**Your Ref:** OWPC5178  
**Our Ref:** A/10/15/PL 28-01-2015  
**Please ask for:**  
Mrs A Gardner

2 No. detached houses with garages. This is a Departure from the Development Plan.  
Land at West Drive Ham Manor Estate Angmering

Thank you for your internet representation made on 19th March 2015 which has been recorded as '**an objection**' with the comments as follows:

ELEVATIONS
PLOT 1

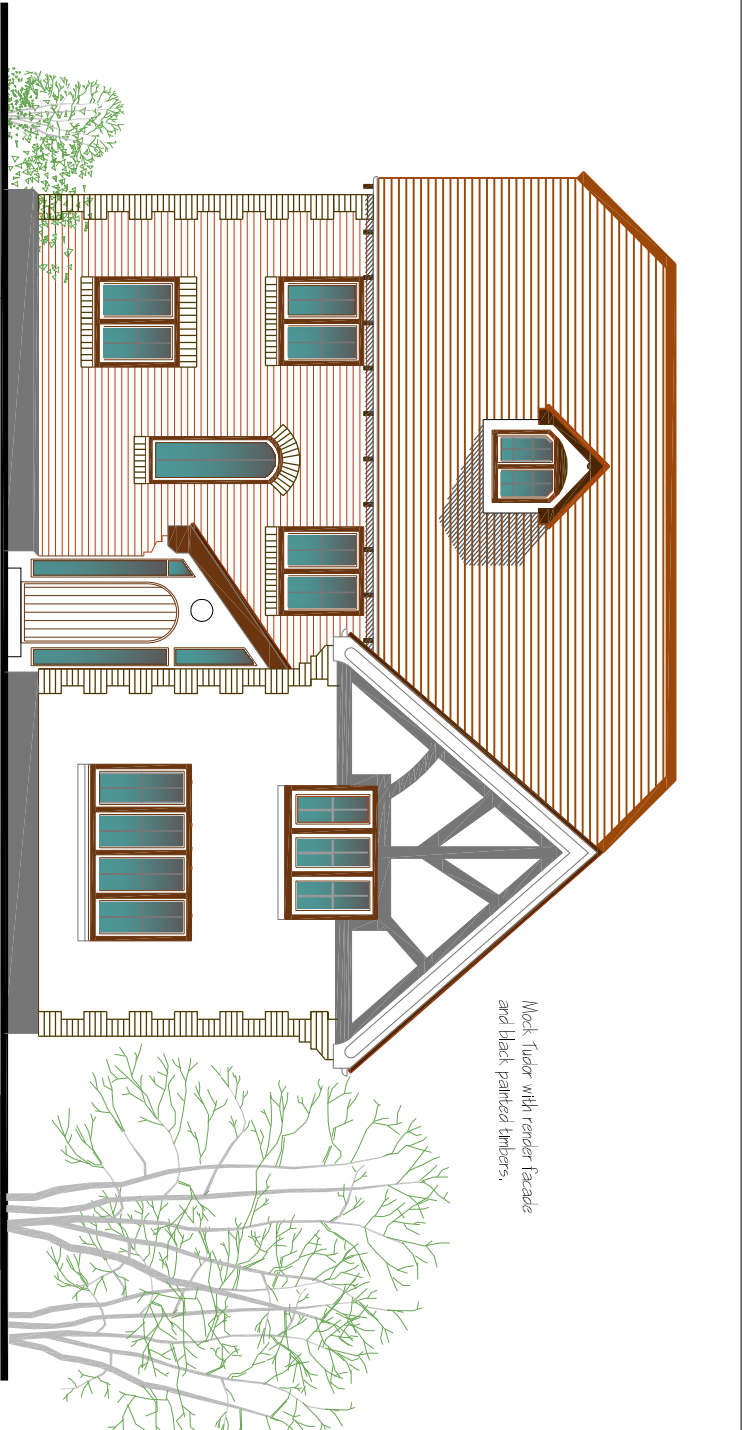
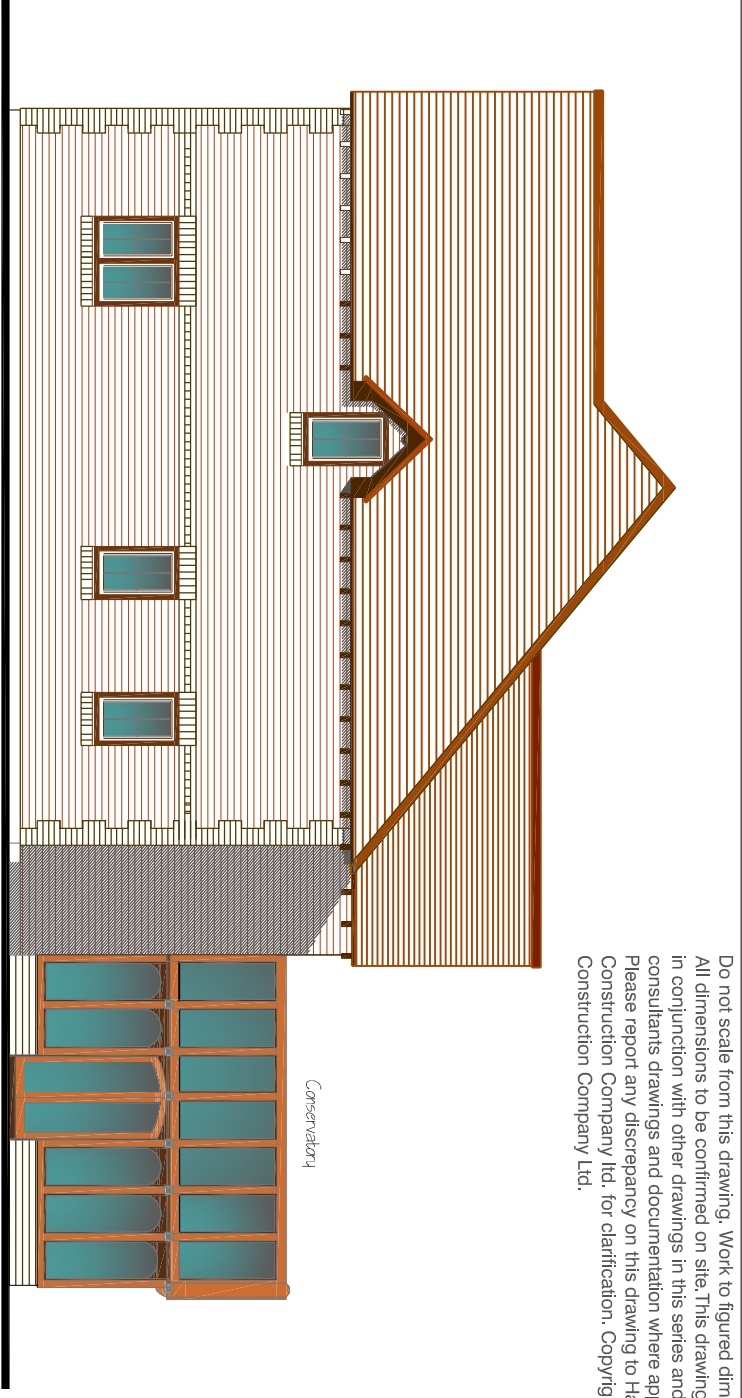
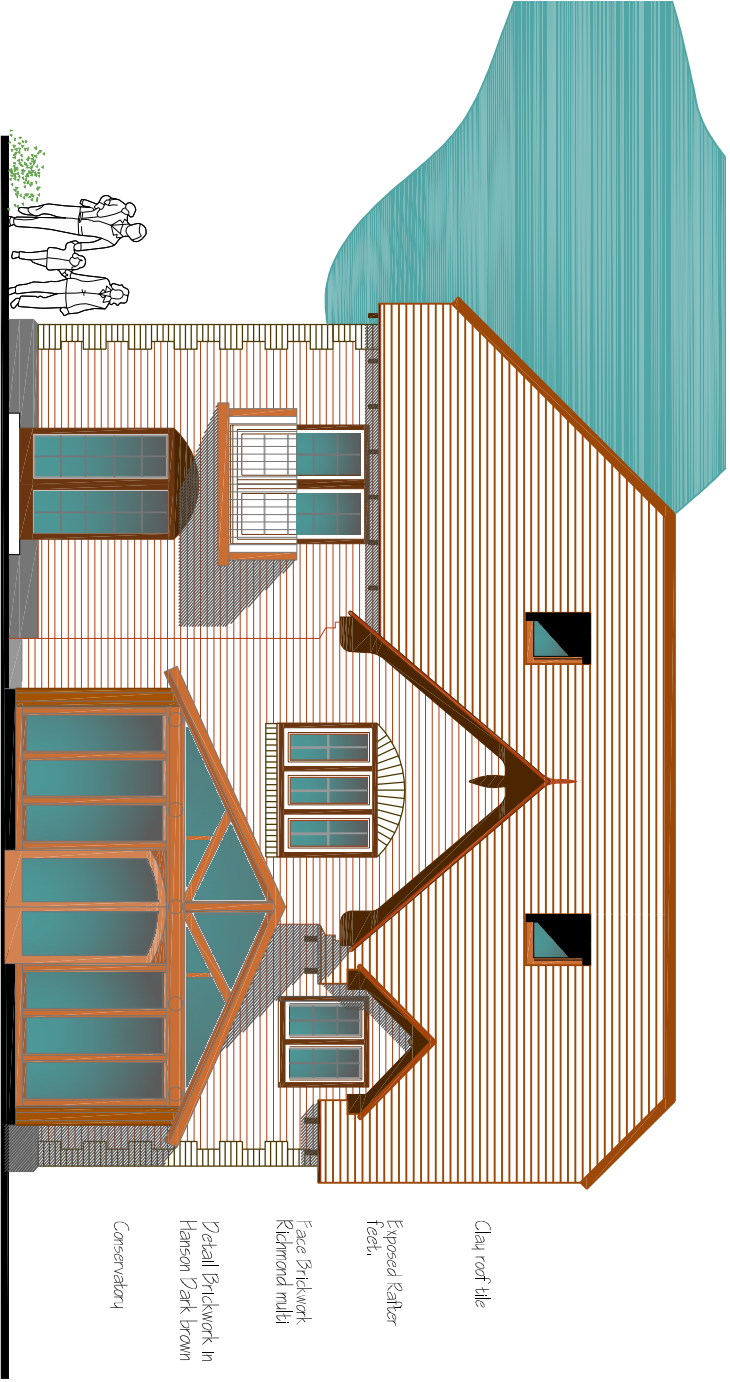
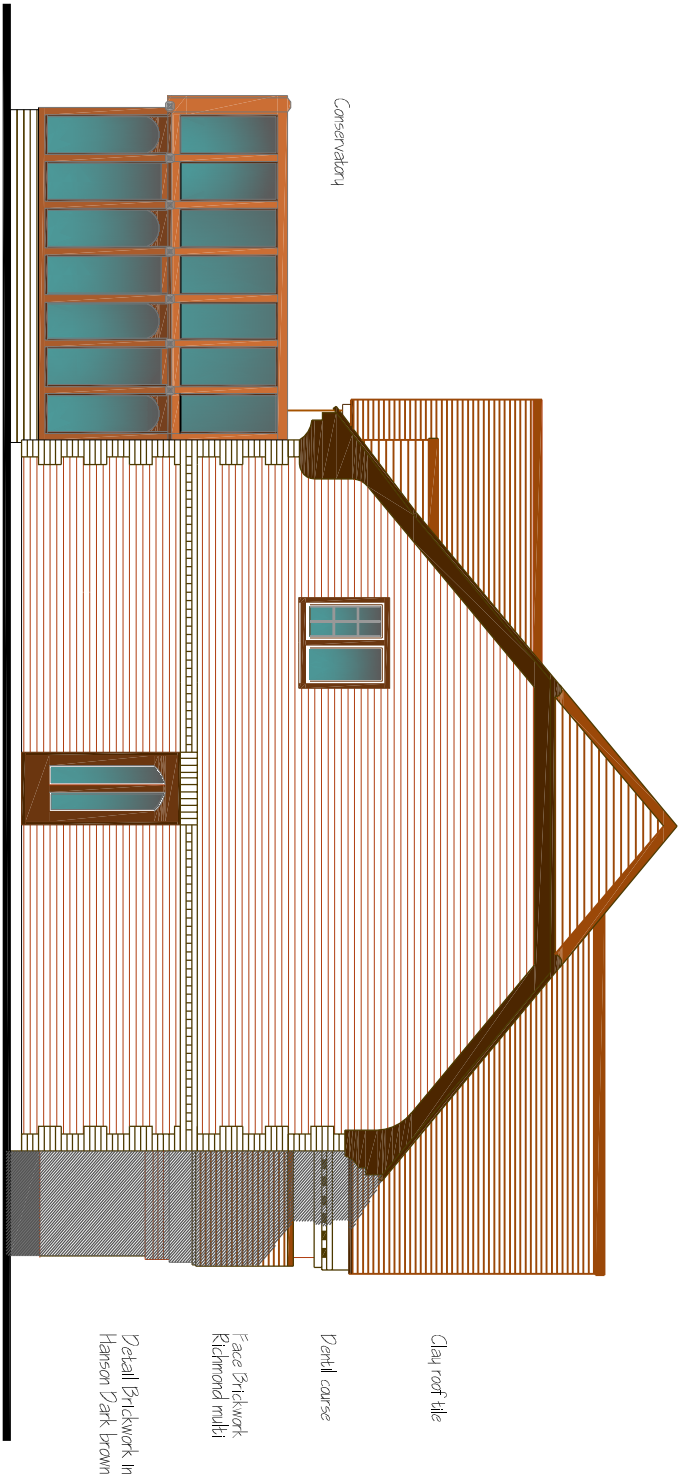
*We live at No 80 and our property is directly opposite the site facing west. My objection is due to the fact that the proposed rooflines will be significantly higher than other houses in the vicinity and will actively encourage use of the roof space as a living area due to the 2 windows situated in it. The site is already on raised ground anyway.*
